Application number: 2025/92713	
What is the application for?:	Reserved matters application pursuant to outline permission 2023/92079 for erect
Address of the site or building:	Rear of, 23 to 43, Moor Lane, Gomersal, Cleckheaton, BD19 4LF
Postcode:	LS10 1NB

Type of comment: An objection	
Do you wish your comments to be published on the website anonymously?	Yes
<p>Outline Planning Permission was granted to Binks Developers in December 2023. The owners signed an agreement to follow all the section 106 conditions imposed by Kirklees.</p> <p>Binks subsequently advertised the site for sale with Michael Steel & Co - "our ref 1135A/M updated Sept 2024". A plan showing outline permission for 6 x 3 bed and 4 x 4 bed houses appears in the sales brochure.</p> <p>On application 2023/93079 report id 1007435 under "Committee" which recommended outline be granted this time by the planning committee, reference is made to the planning conditions to be secured by a section 106 agreement.</p> <p>PPJ have failed to adhere to all the outline planning conditions listed below:-</p> <p>3.3 - reasons the planning sub committee first refused planning ref 2022/92100.</p> <p>3.4 - the few changes Binks made i

PLOT 1

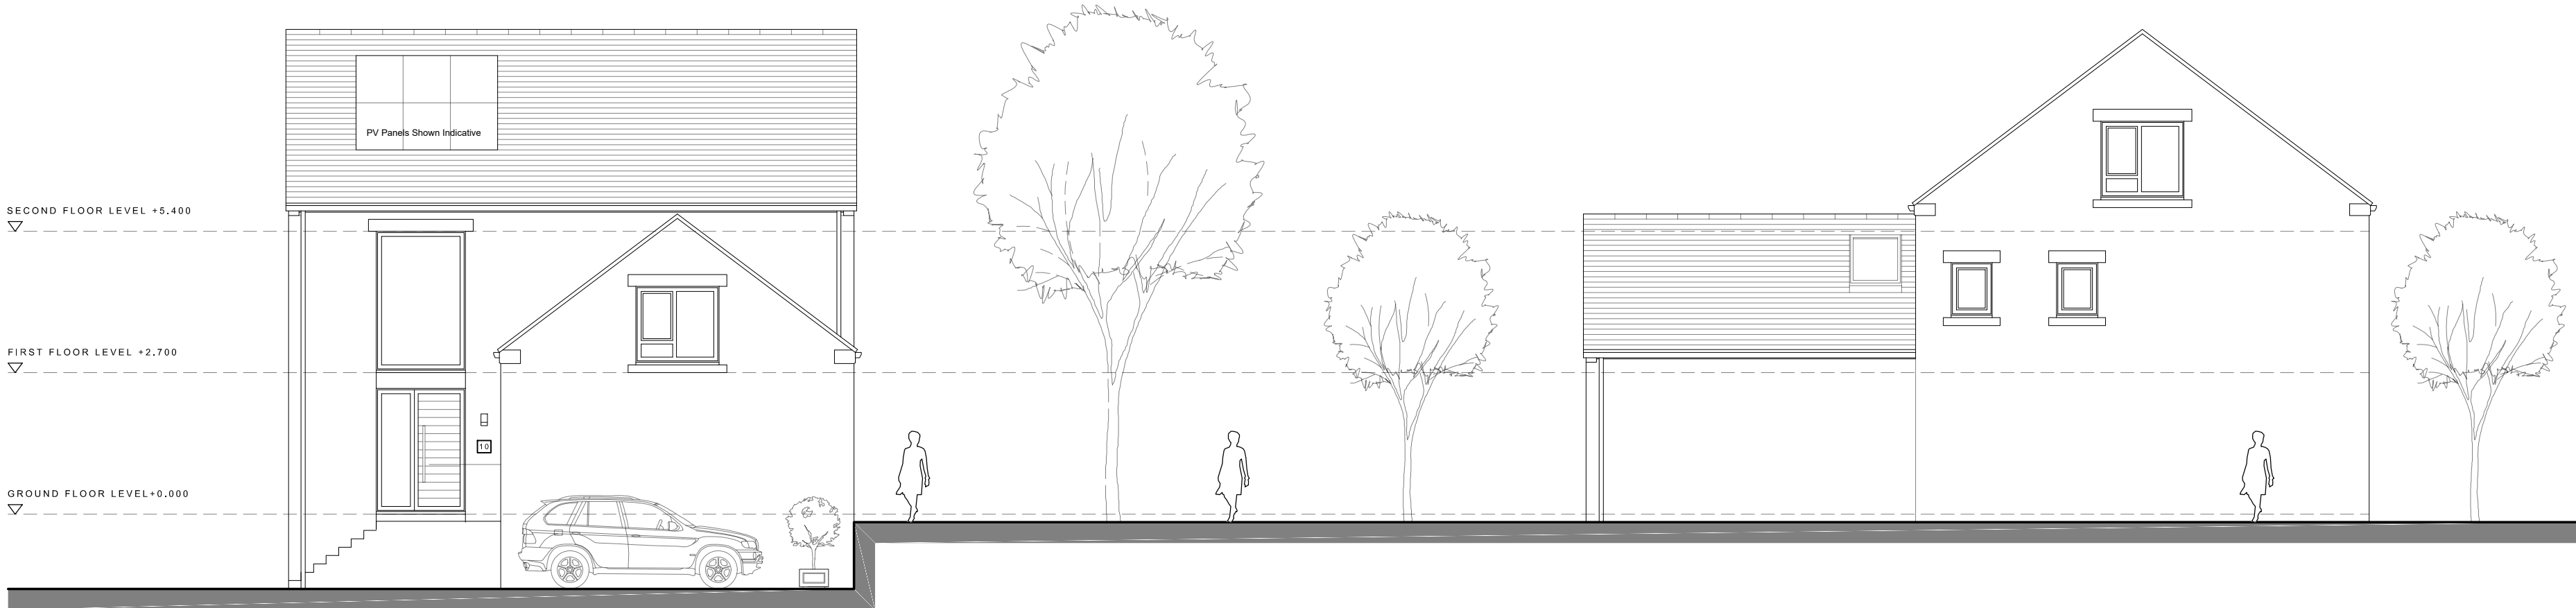
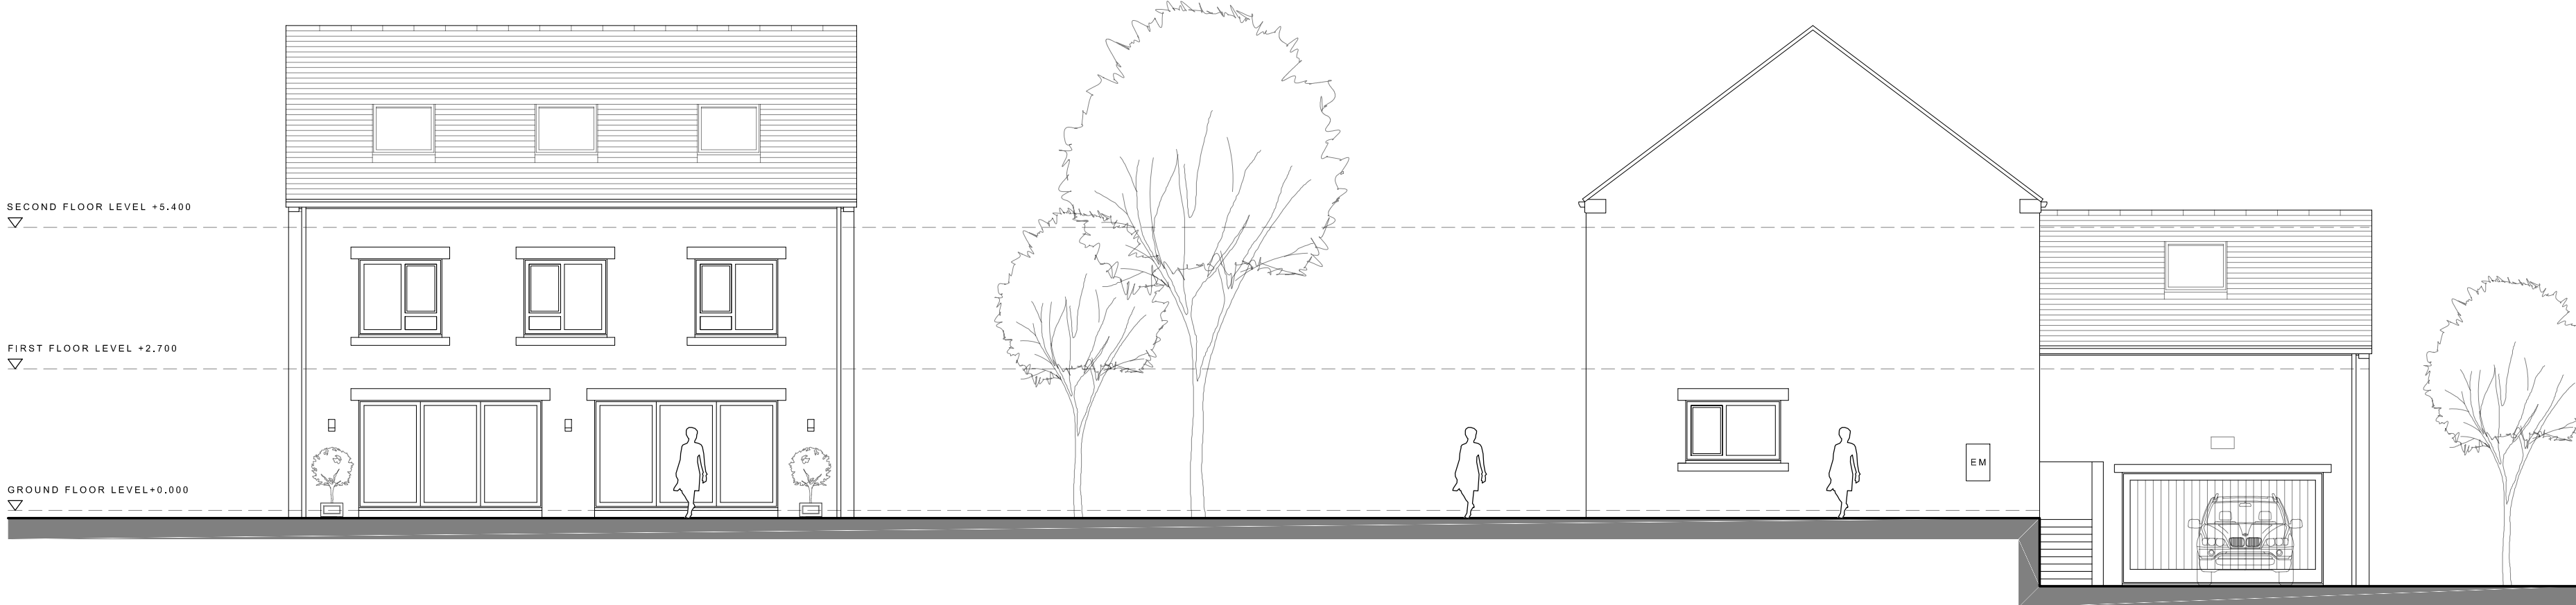
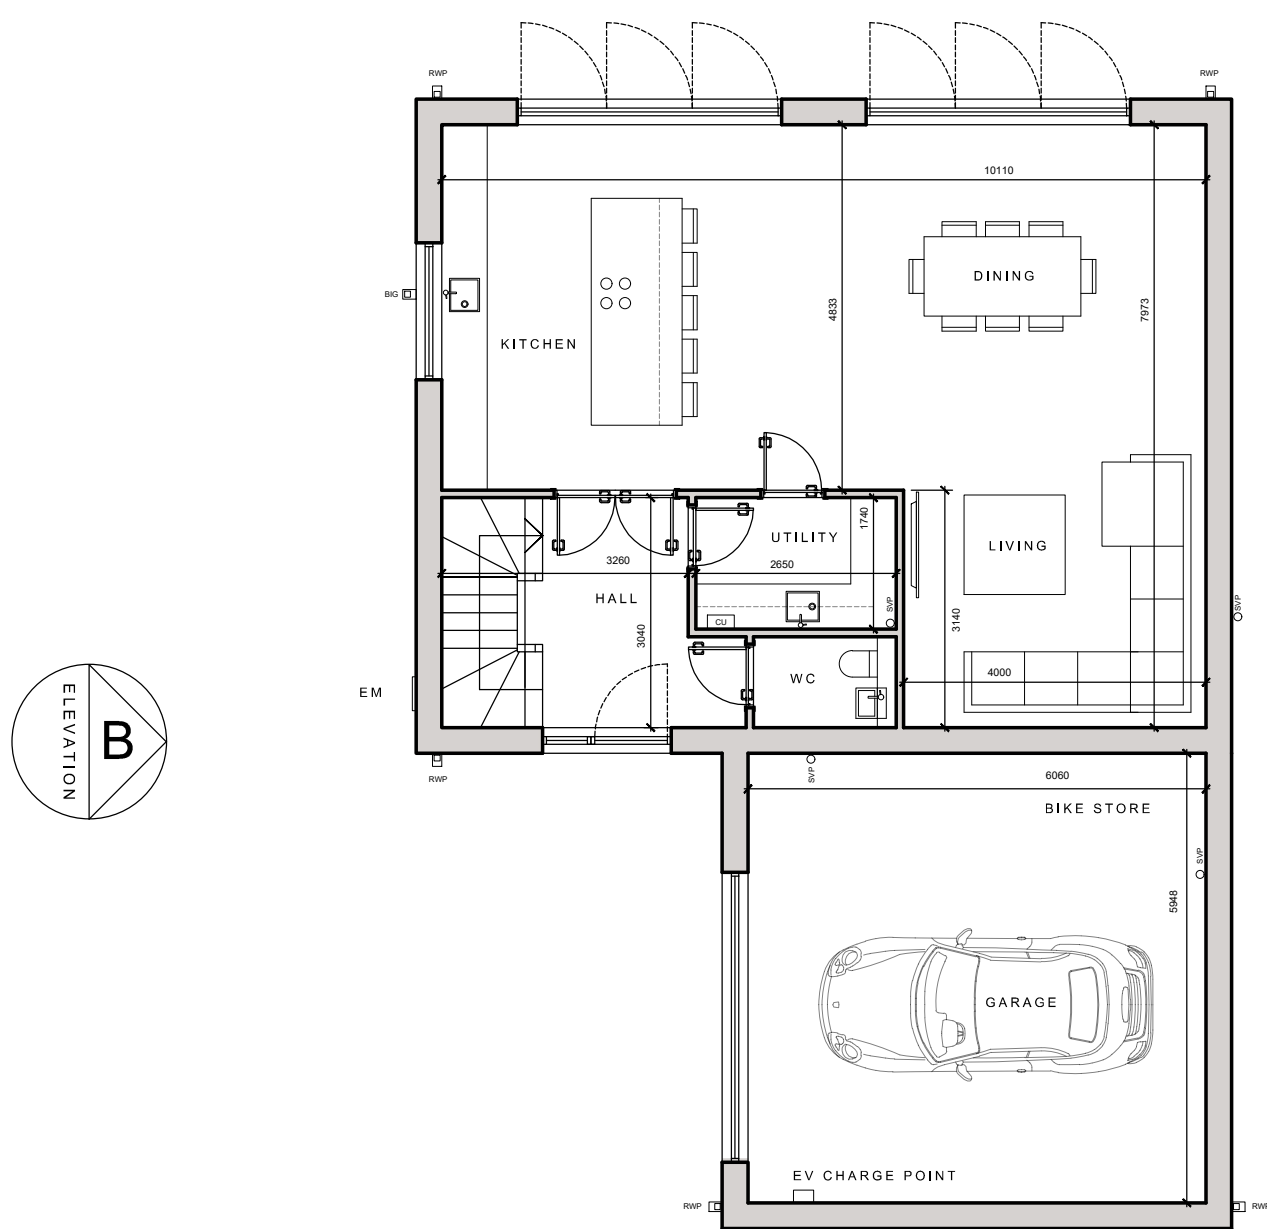
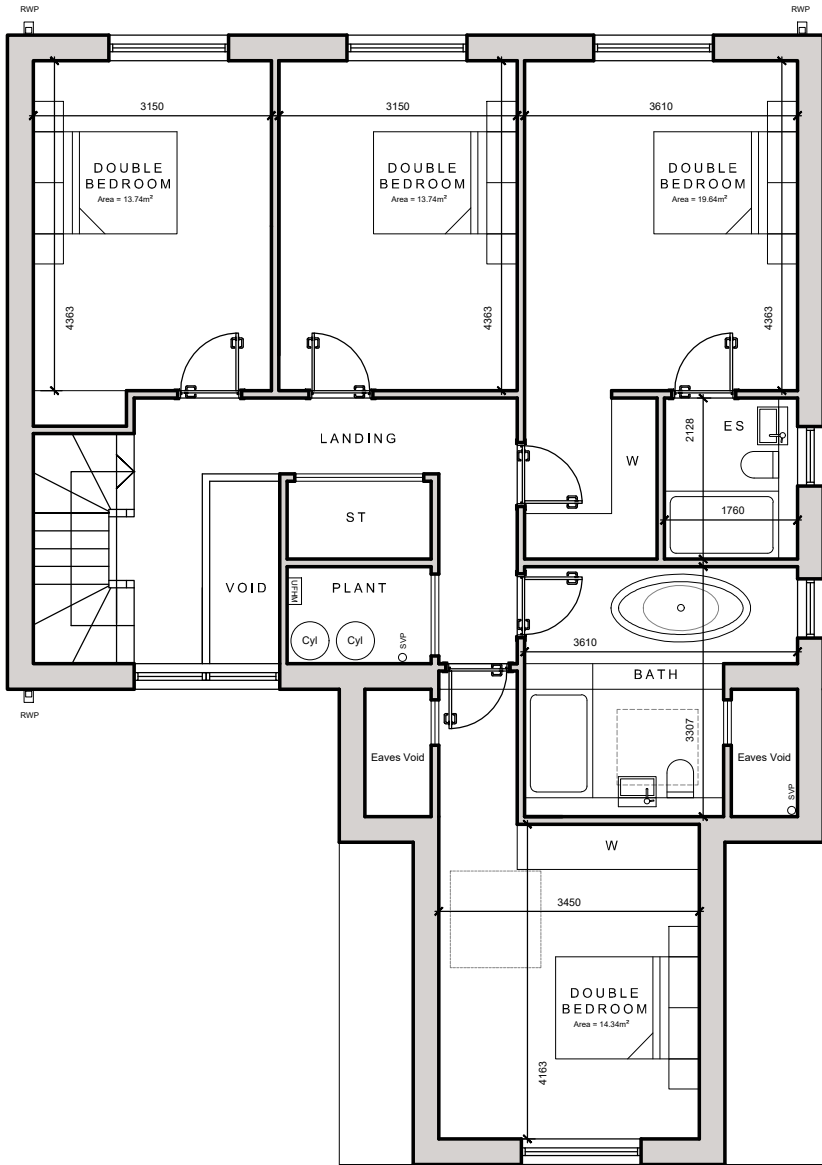
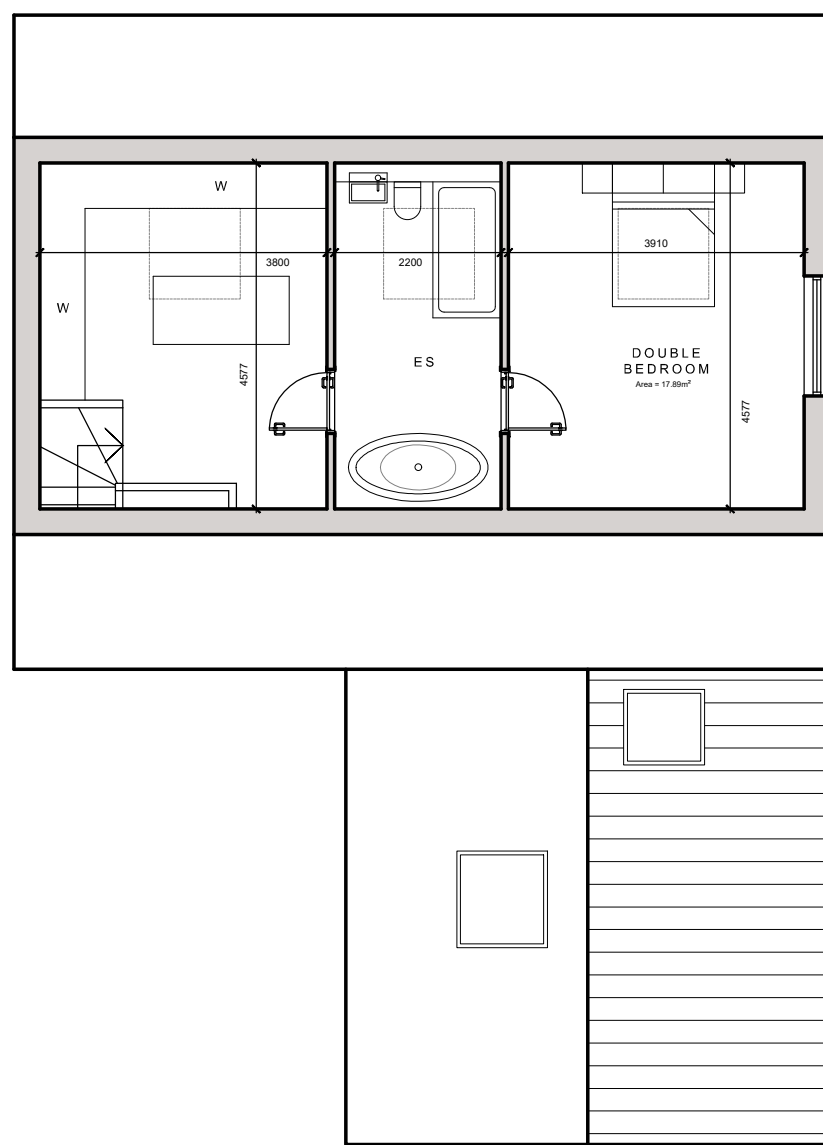
The housing mix - plots 1 and 10 should be smaller 4 bed houses - there is no permission for 5 bed homes

Plots 1 and 2 should be moved further into the development
